February 27, 2001

RE: Shops @25(F17-D46A) - Drainage Re submittal

**RE: Drainage Report for Shops @ 25**  
**Plan dated January 18, 2001**  
**Drainage File # F17/D46A Tract I**  
**Request for Site Development Plan for Building Permit, Building Permit Approval, and**  
**Grading Permit**

2 LIFTS-1 1/2" CLASS "B" ASPHALT
	8" AGGREGATE BASE COURSE
	12" COMPACTED SUBGRADE TO 95% ASTM D-1557

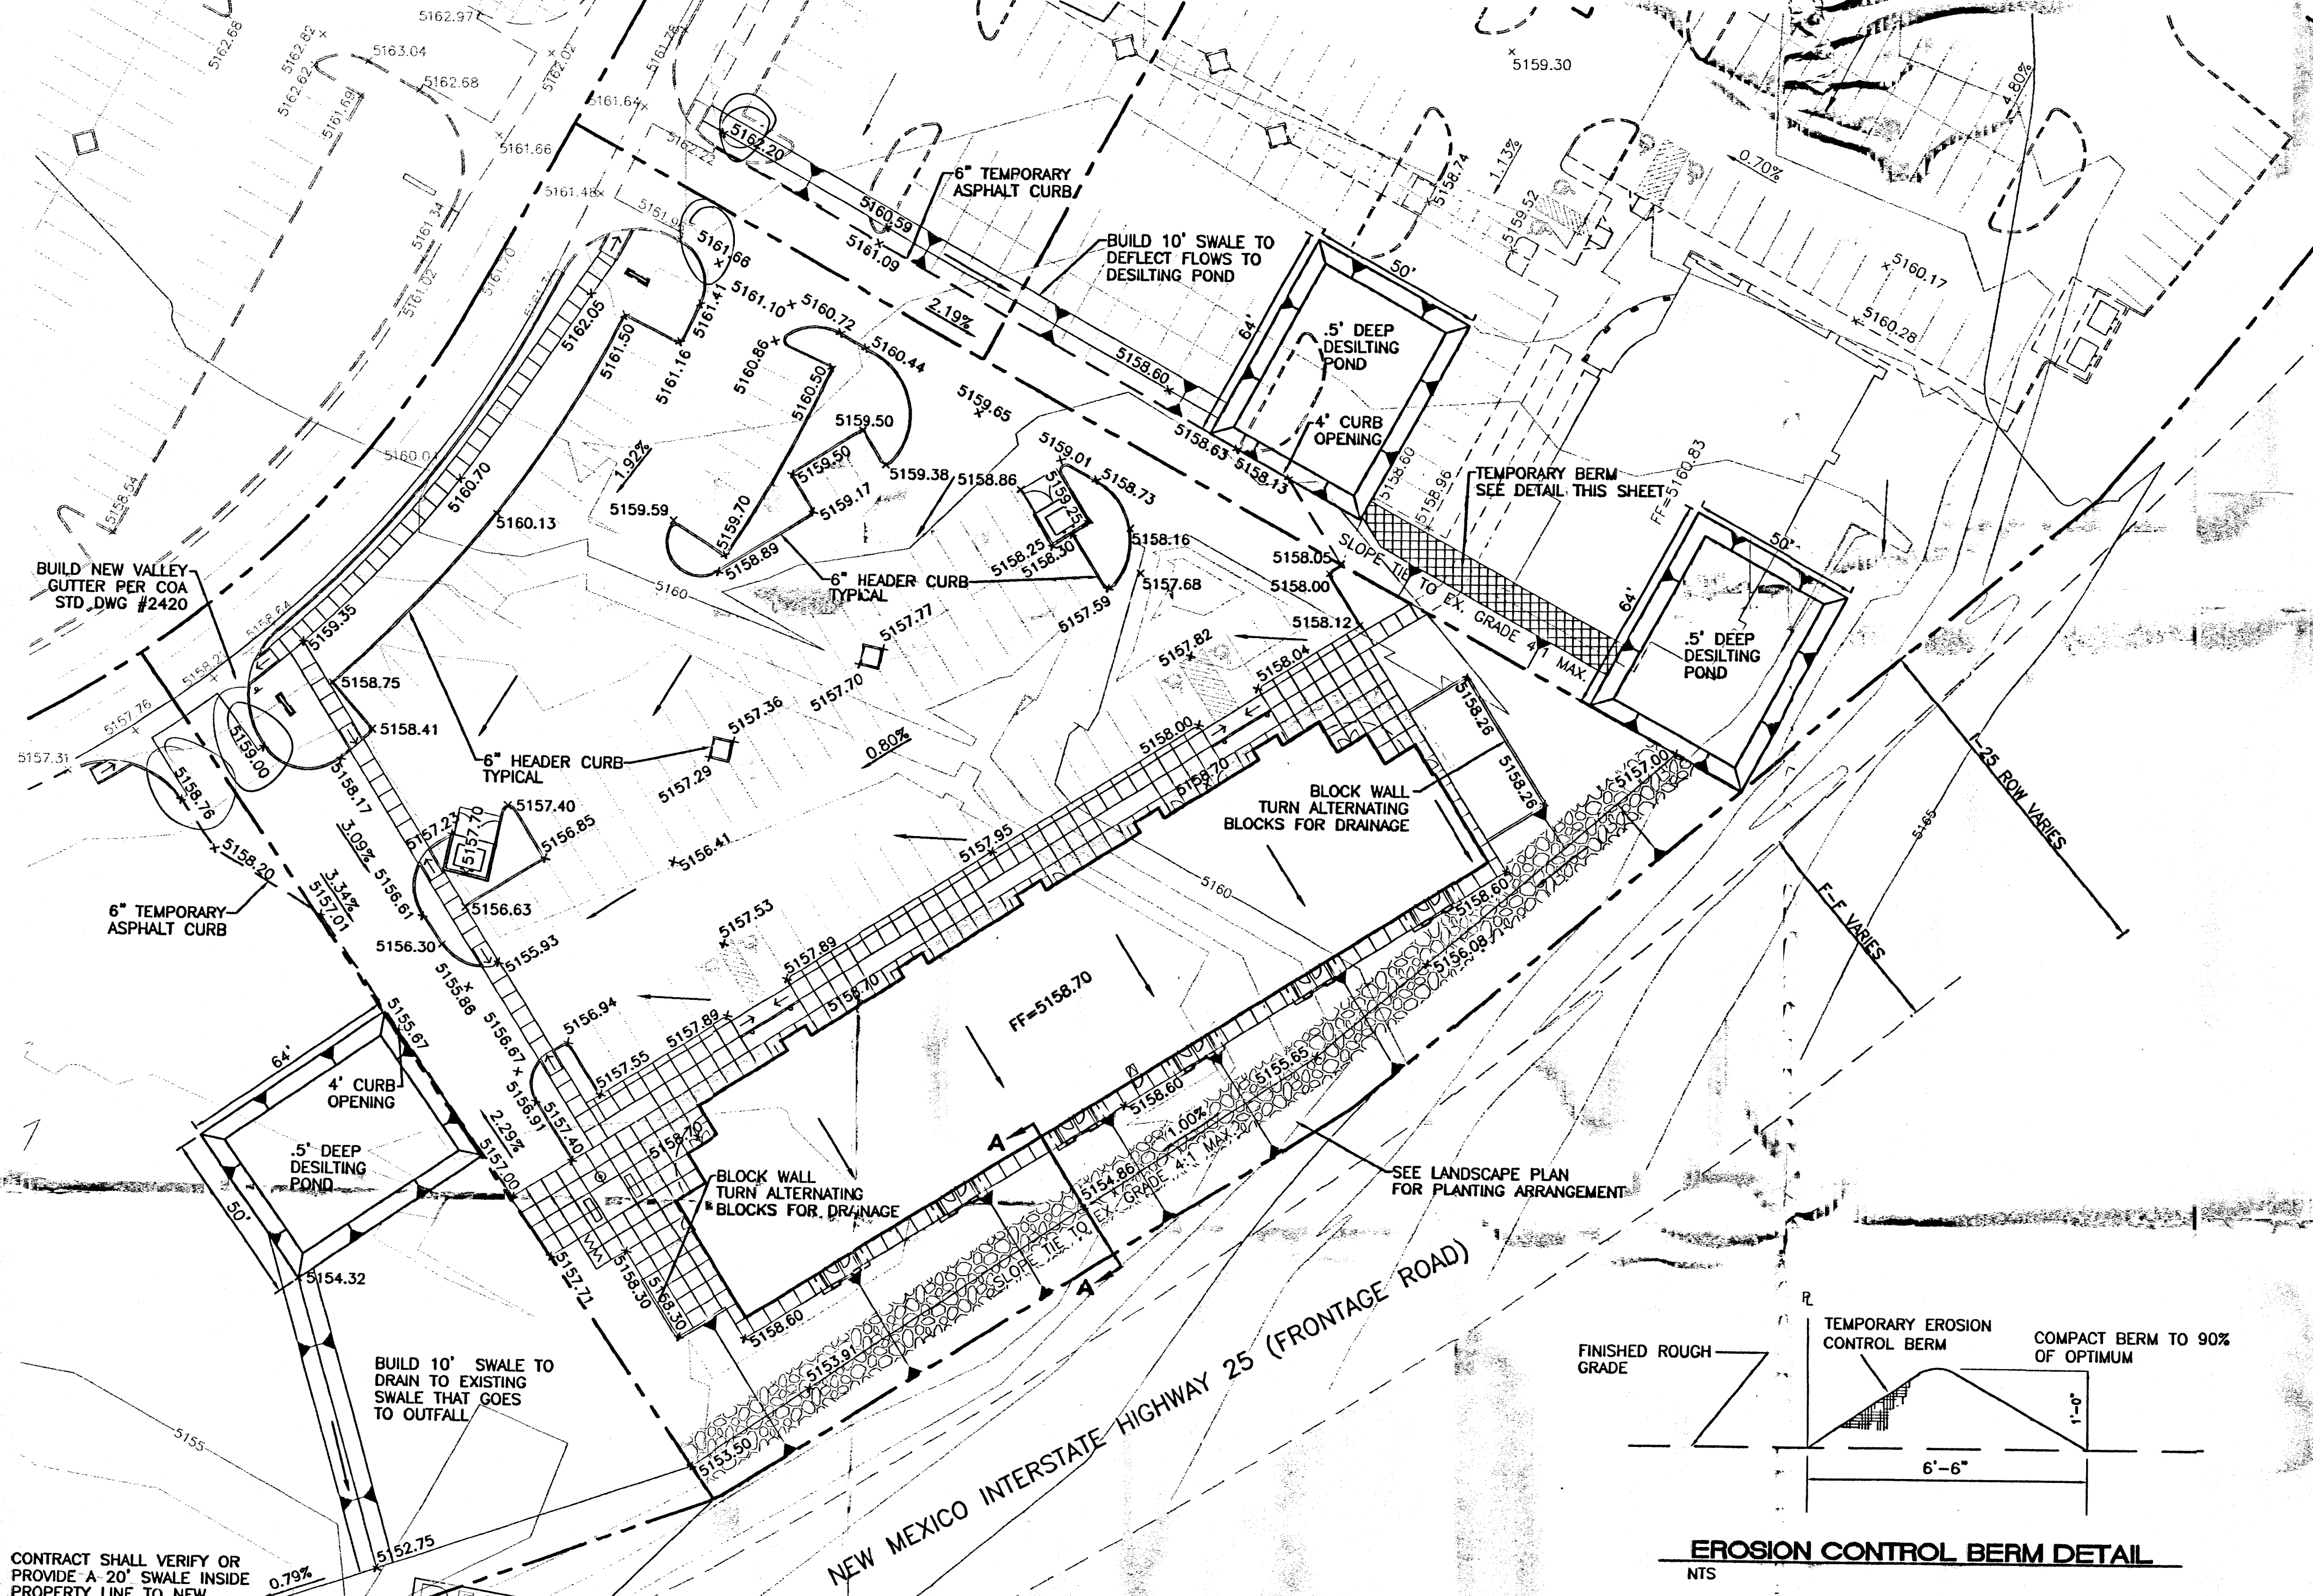
**The design calculations have been added to Appendix A of the revised Drainage Report.** ✓
3. Verification that the 42" Storm Drain will fit in the back of the existing catch basin in Jefferson.

**A cross section of the existing inlets showing the new penetration has been provided on the profile sheet, sheet 2 of 2.** ✓
4. Identify the maintenance responsibilities for the private off-site desiltation ponds and riprap channel. *need*
